ADC PARKS & GREENSPACE ARBORICULTURE

PLANNING APPLICATION: LU/201/16/RES

ADDRESS: Windroos Nursery Worthing Road Littlehampton BN17 6LY

BRIEF DESCRIPTION: Approval of reserved matters following outline consent LU/229/10/ for appearance, landscaping, layout & scale for 85 No. dwellings

CLIENT	STUART & MARCIA LYONS
PROJECT	WINDROOS, LITTLEHAMPTON
TITLE	PROPOSED SITE PLAN - SHEET 2 OF 2

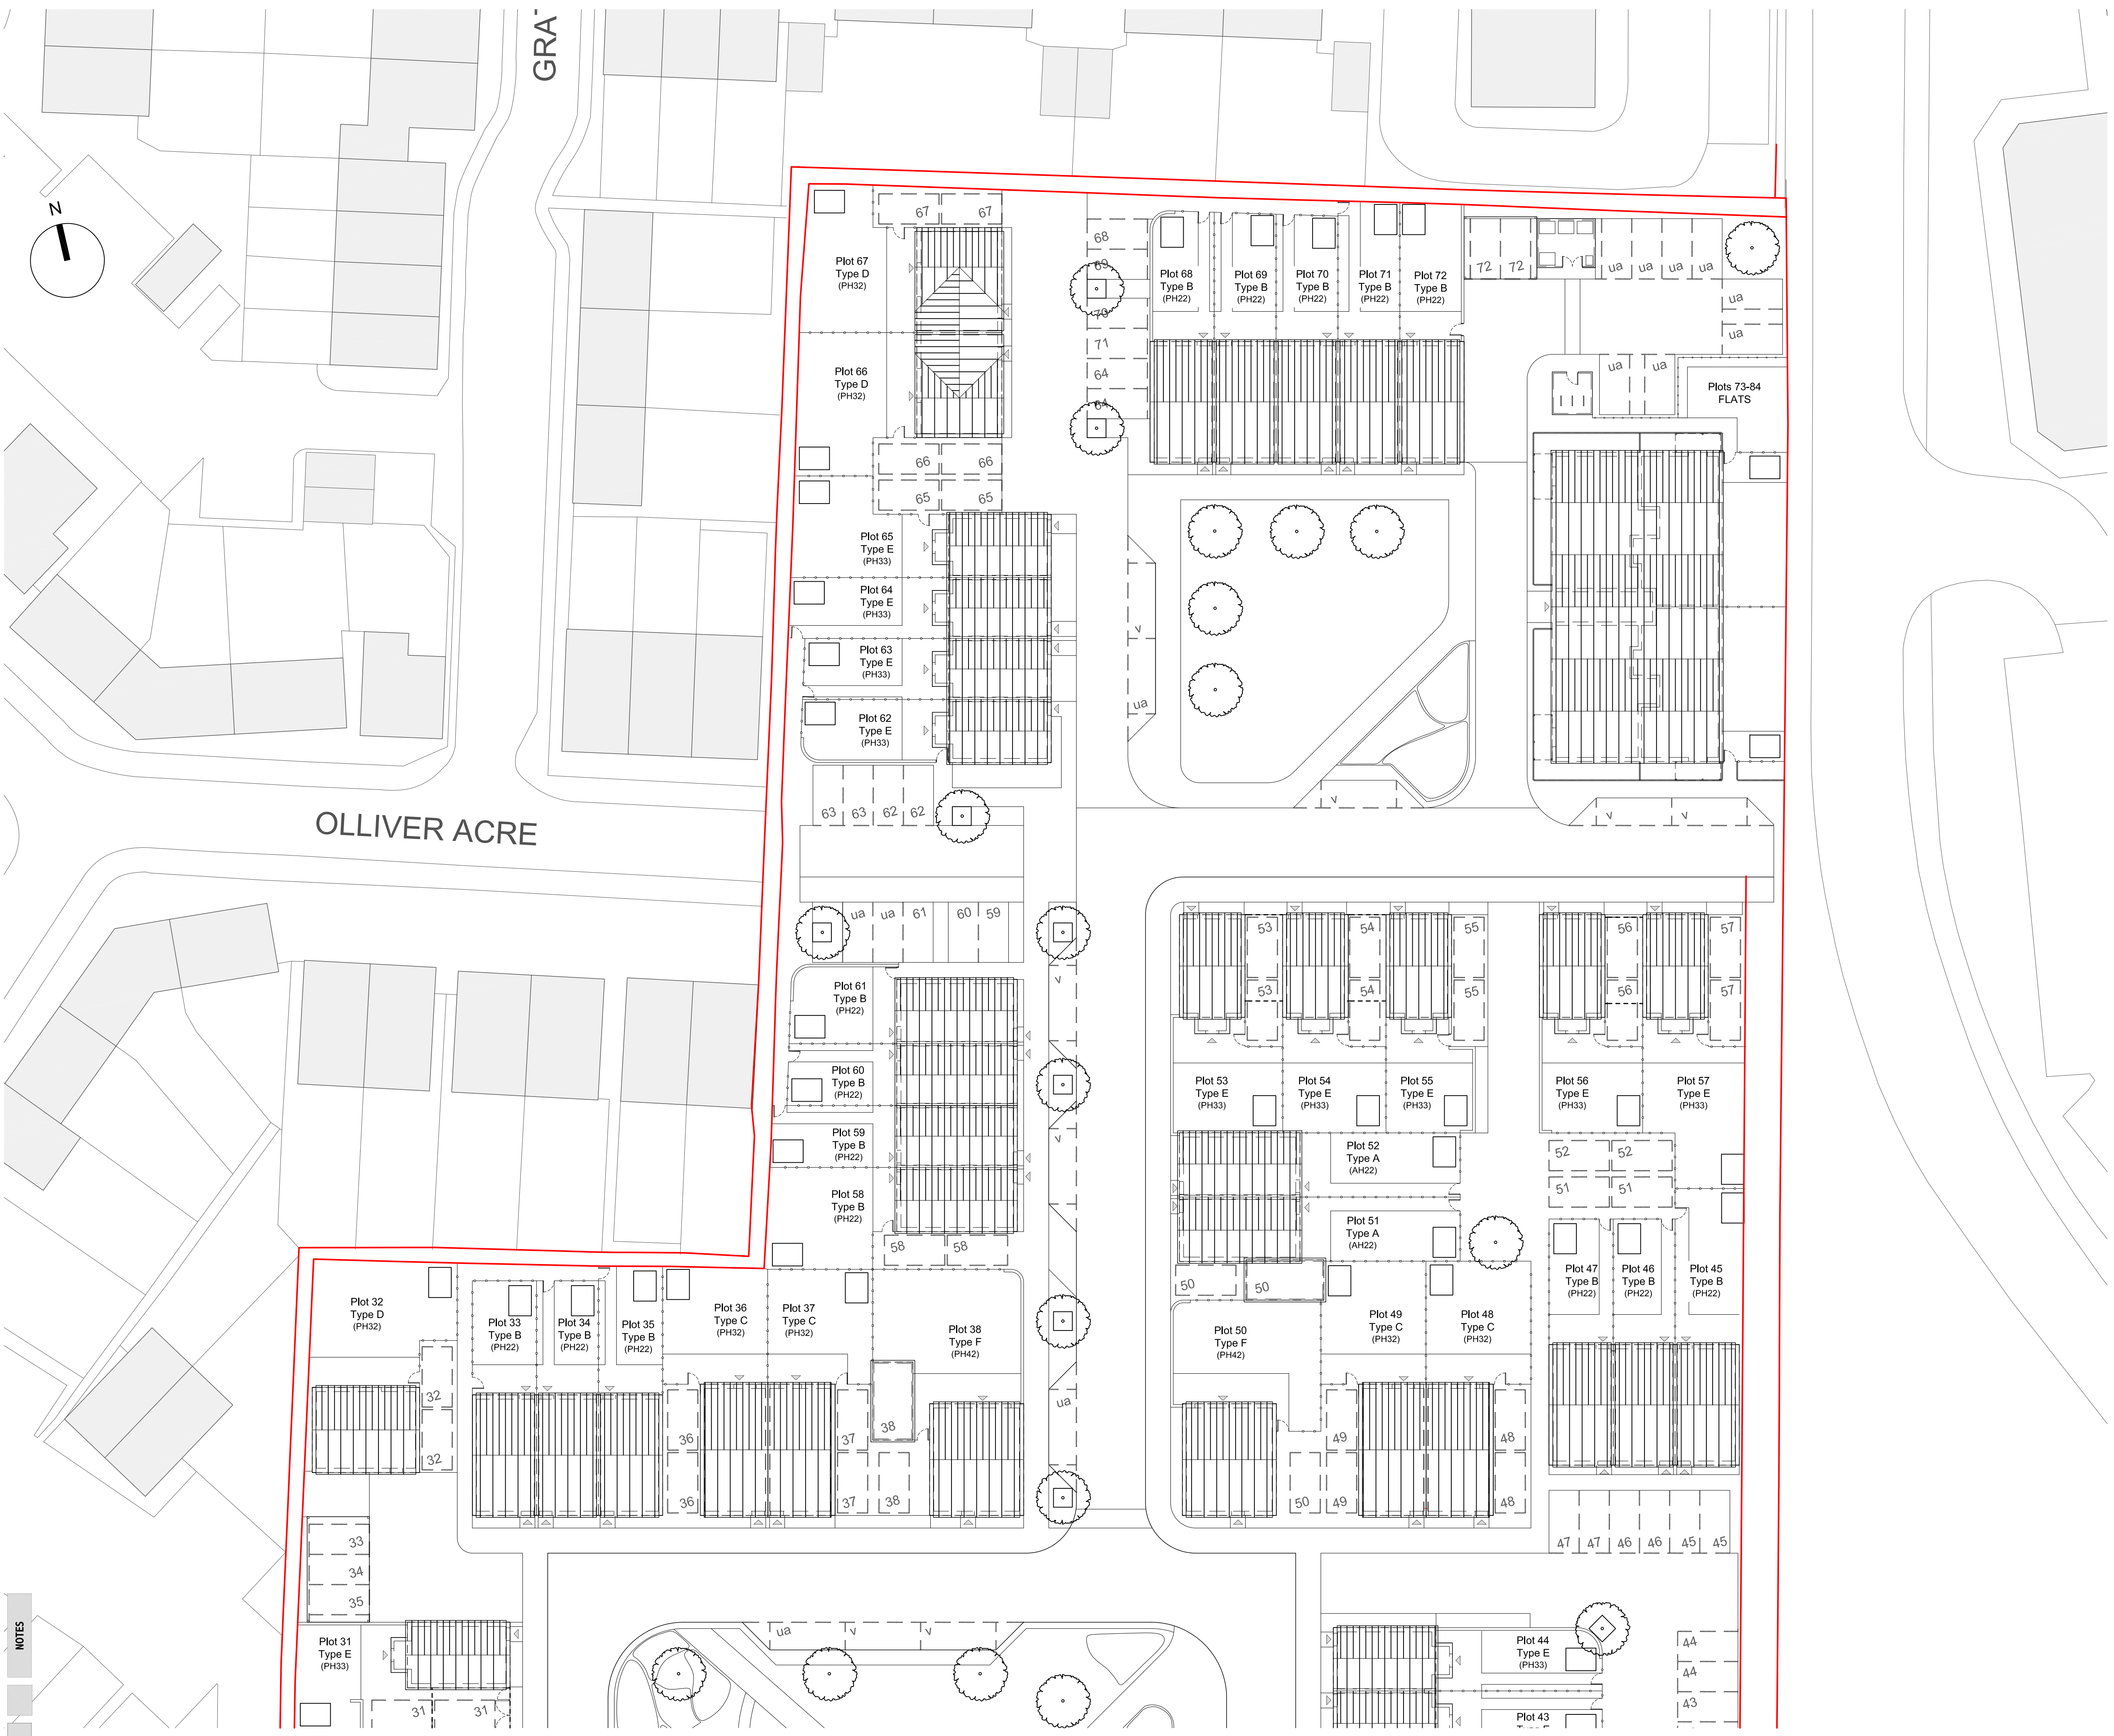
- For **T3** and **G6**, the tree protection plan & photos does appear to illustrate a clear overlap with the footprints of proposed units 45 and 41 respectively. If this overlap is accurate the applicant has failed to outline the construction/mitigation techniques that would be used to prevent damage occurring to the given RPA's of **T3** and **G6**
